**Our Case Number:** ABP-313509-22

**Re:** BusConnects Belfield/Blackrock to City Centre Core Bus Corridor Scheme  
Co. Dublin

Bus Connects  
UCD Ballsbridge to City Centre (Part of Belfield / Blackrock to City Centre Core Bus Corridor Scheme)  
Reference No. ABP 313509-22  
Submission by Hilary and Rosemary Hough, 79 Nutley Lane

**Observations by Hilary and Rosemary Hough, 79 Nutley Lane**

**TYPICAL SECTION V-V**  
**NUTLEY LANE**  
 LOCATED ON GA SHEET 22  
 DRAWING REF: BCIDC-ARP-GEO\_GA-1415\_XX\_01-DR-CR-0022

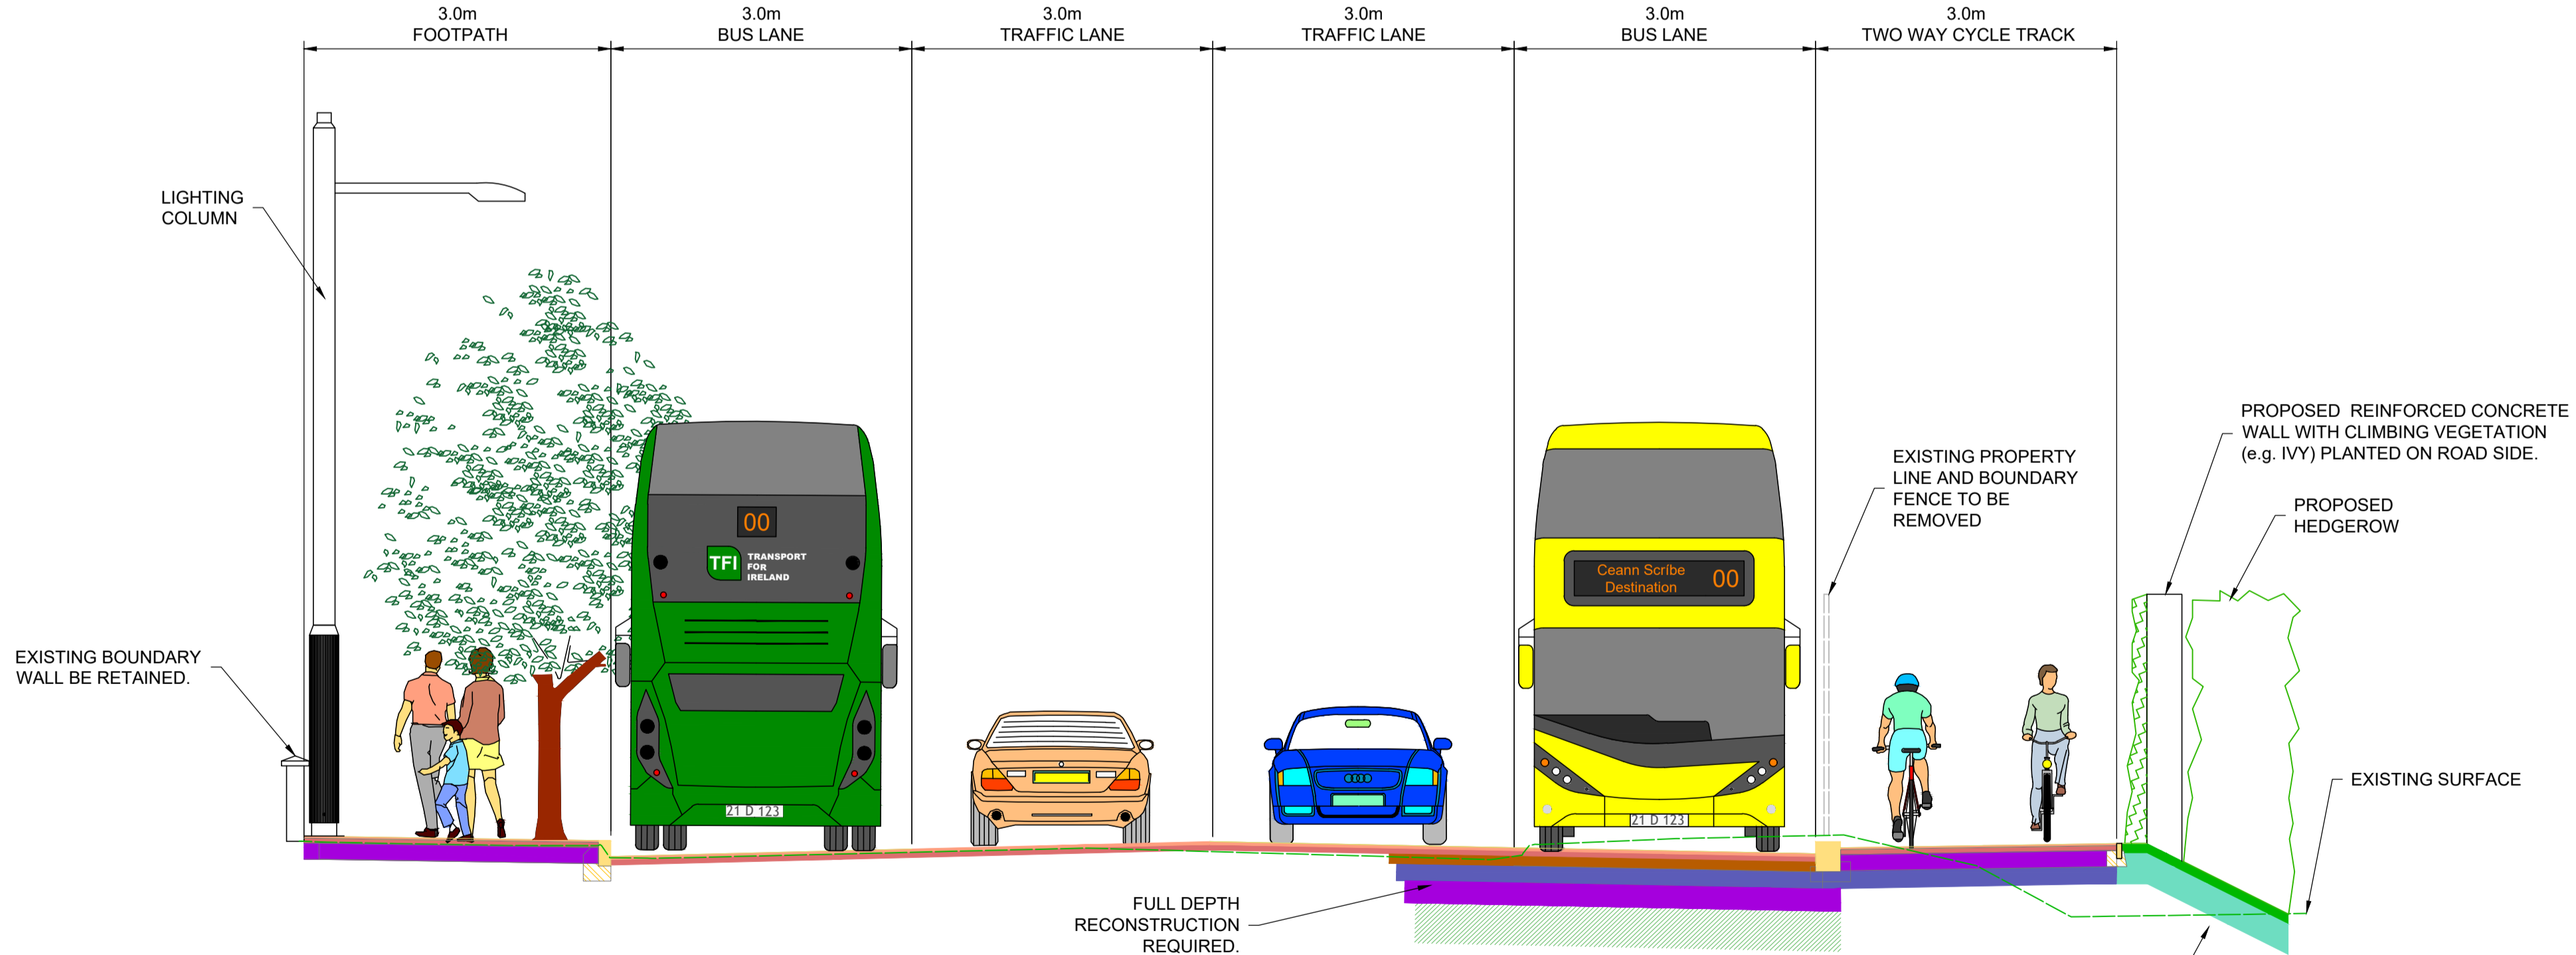
Nutley Lane currently has capacity to accommodate three vehicle lanes and one cycle lane. The inclusion of a fourth vehicle lane is to facilitate cars which goes against the overall objective of reducing the usage of cars and increasing usage of public transport. Additionally the inclusion of a fourth lane also has the greatest negative environmental impact both in terms of the destruction of trees and hedges and increased air and noise pollution resulting in a diminution of the quality of life of the residents and negatively impacting their physical and mental well being. As a result of the potential impact on the quality of life a number of residents on Nutley Lane have put their houses on the market but have been unable to find purchasers because of the Bus Connects proposals for Nutley Lane.

**Figure 3.67: Route Option NL2 Indicative Scheme Design**

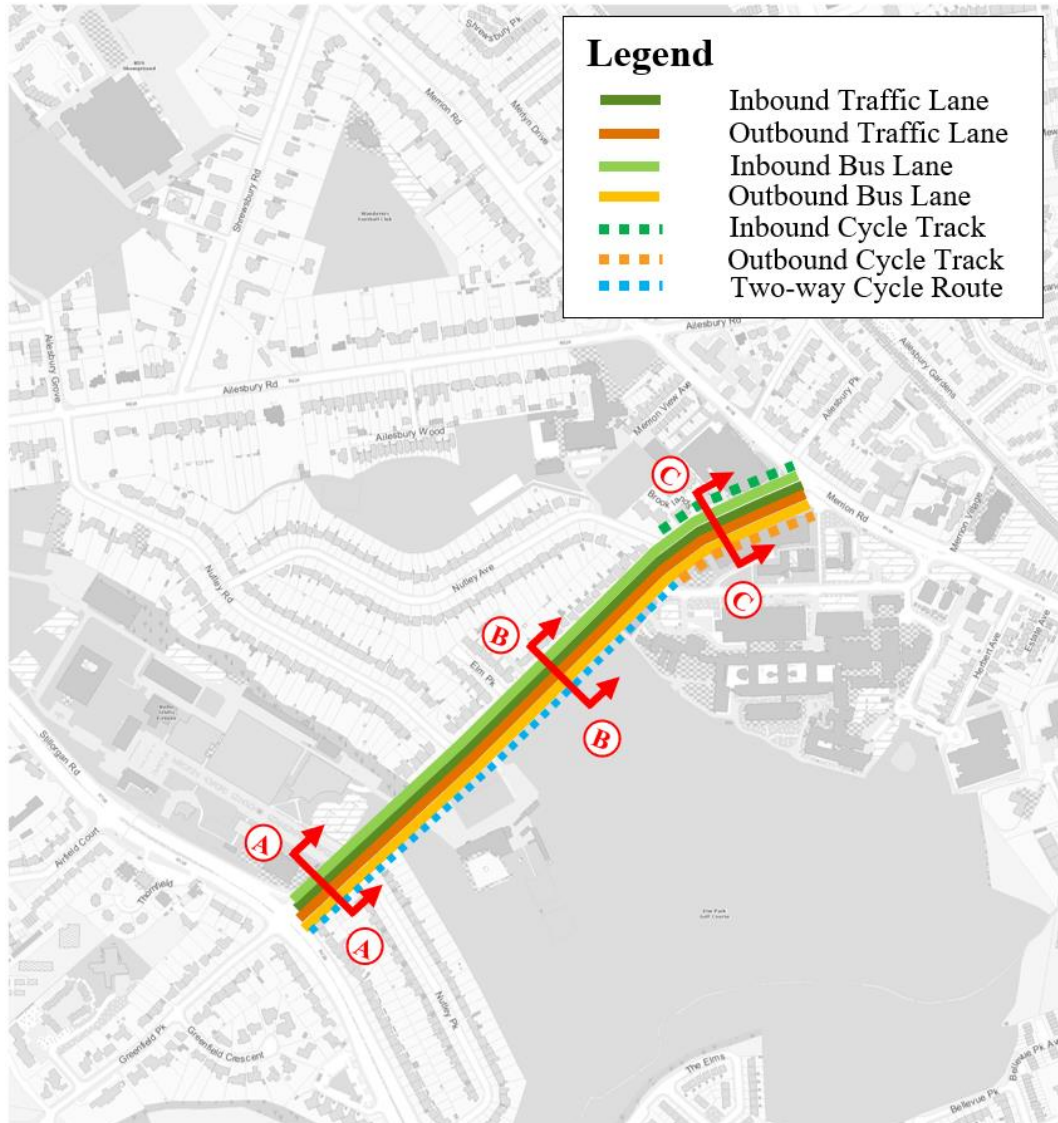
In particular we draw An Bord's attention to the fact that the chosen option NL2 ranks least well of six of the options reviewed by the NTA in terms of environmental impact.

Option NL2, involves the removal of c80 mature trees, many of which are up to 15mtrs high and some up to 100 years old, along the eastern boundary of Nutley Lane and the removal of 2 hedgerows, approx. 3mtrs high, along the boundary of the Elm Park Golf Club, to be replaced by a 'reinforced concrete wall with climbing vegetation (e.g. ivy) planted on the road side, and a hedgerow reinstated on the golf course side' and along the boundary of SVUH.

The reason why it ranks least well of the options is that it proposes four rather than three traffic lanes. This fourth lane is for the exclusive of cars which goes against the overall objectives of Bus Connects to reduce car usage and, ironically, it is this additional car lane which will lead to the destruction of the trees and hedges.

The NTA preferred option, Option NL2, involves the removal of c80 mature trees, many of which are up to 15mtrs high and some up to 100 years old, along the eastern boundary of Nutley Lane and the removal of 2 hedgerows, approx. 3mtrs high, along the boundary of the Elm Park Golf Club, to be replaced by a 'reinforced concrete wall with climbing vegetation (e.g. ivy) planted on the road side, and a hedgerow reinstated on the golf course side' and along the boundary of SVUH.

(A concrete wall would be totally inappropriate and should have been proposed to be of granite or other natural brick to minimise the visual and environmental impact on a residential area)

The preferred option Option NL2 ranks least well of six of the options reviewed by the NTA in terms of environmental impact.

The reason why it ranks least well of the options is that it proposes four rather than three traffic lanes. This fourth lane is for the exclusive of cars which goes against the overall objectives of Bus Connects to reduce car usage and, ironically, it is this additional car lane which will lead to the destruction of the trees and hedges.

**Figure 3.72: Route Option NL3 Indicative Scheme Design**

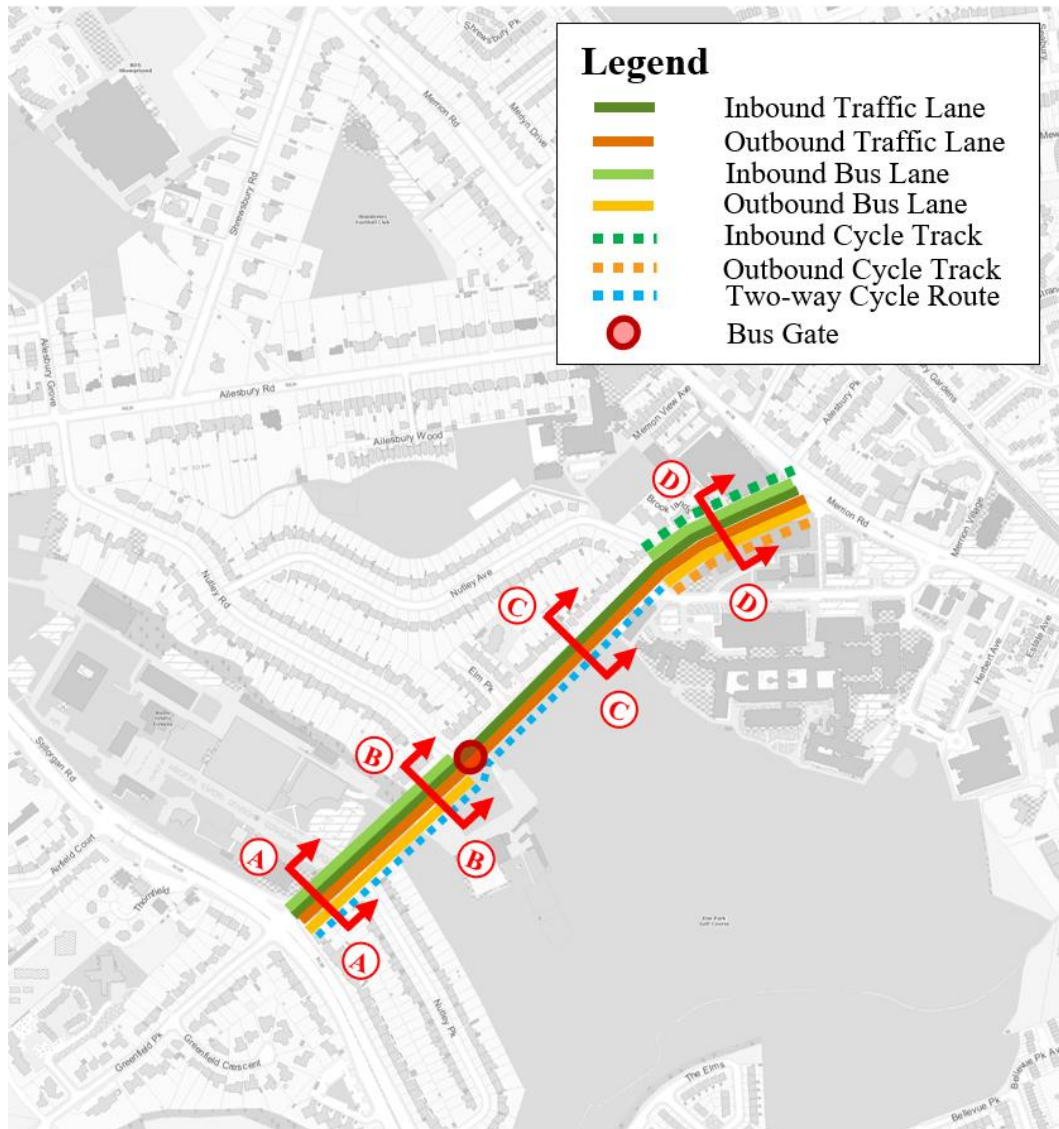
We previously observed and now submit that Option NL3, with some minor amendments, would significantly reduce the environmental impact by retaining most but not all of the trees while at the same time delivering substantially all of the bus traffic objectives of Option NL2

A minor variation on Option NL3 which would improve its effectiveness could be

- Dedicated Bus Lane – Stillorgan Road to Merrion Road
- Dedicated Car Lane – Stillorgan Road to Merrion Road
- Shared Lane Bus/Car – Merrion Road to Stillorgan Road facilitating bus priority by bus priority signalling.
- A 2 way cycle lane

#### **1. Adopting Option NL3**

An alternative option which would be a minor variation on Option NL3 could be

- Dedicated Bus Lane – Stillorgan Road to Merrion Road
- Dedicated Car Lane – Stillorgan Road to Merrion Road
- Shared Lane Bus/Car – Merrion Road to Stillorgan Road facilitating bus priority by bus priority signalling.
- A 2 way cycle lane

**Figure 3.75: Route Option NL4 Indicative Scheme Design**

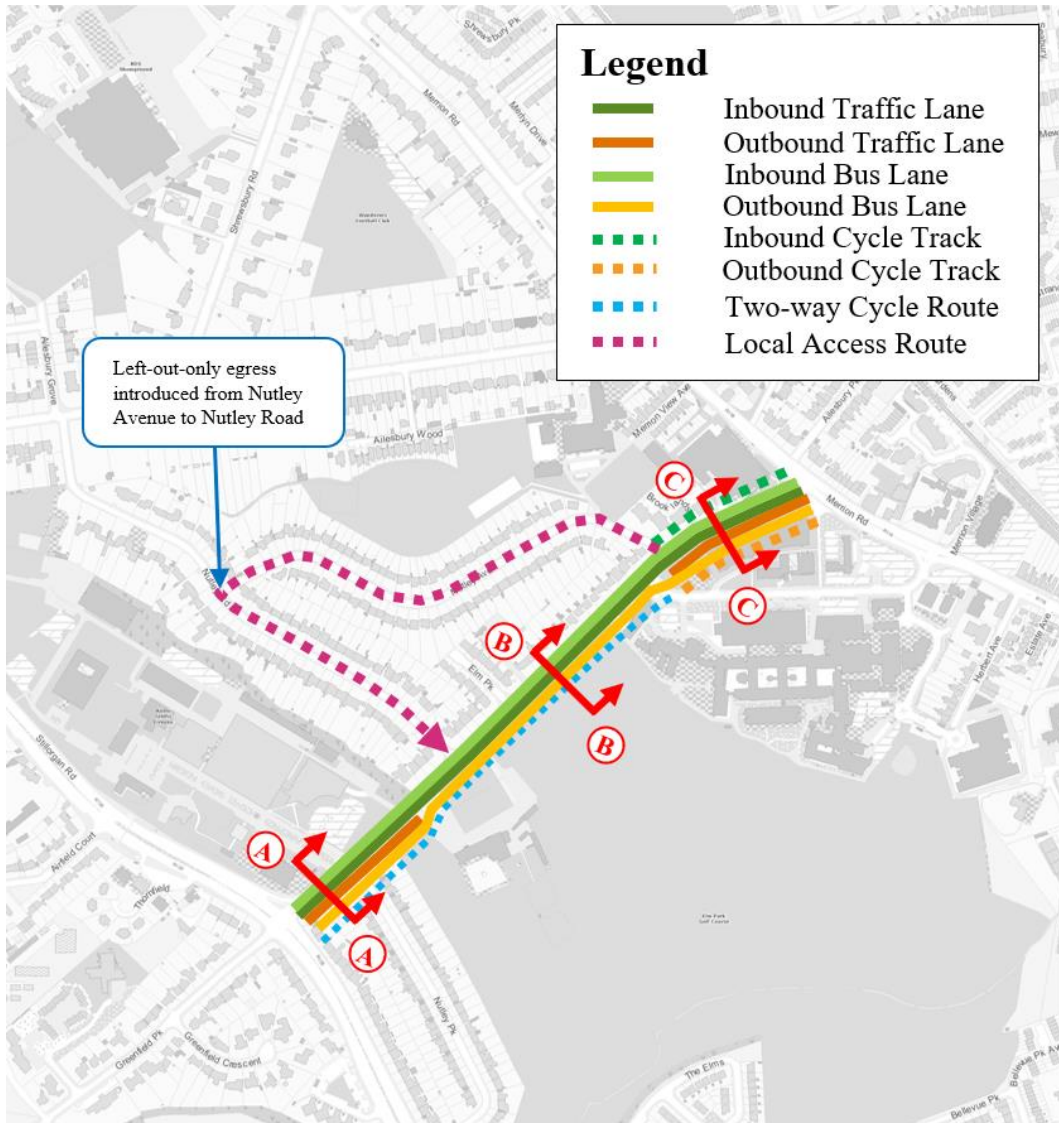
#### **2. Adopting Option NL4**

These options were rejected by the NTA primarily because they contended that they would have a greater impact on bus reliability and timing than the preferred option

We would challenge this rationale for rejection of the options on the following basis:

- The NTA preferred option envisages two traffic light controlled junctions and two toucan crossings on the 700mtr length of Nutley Lane. The impact of these on bus timing reliability would be similar to the impact of the proposals in the rejected options.
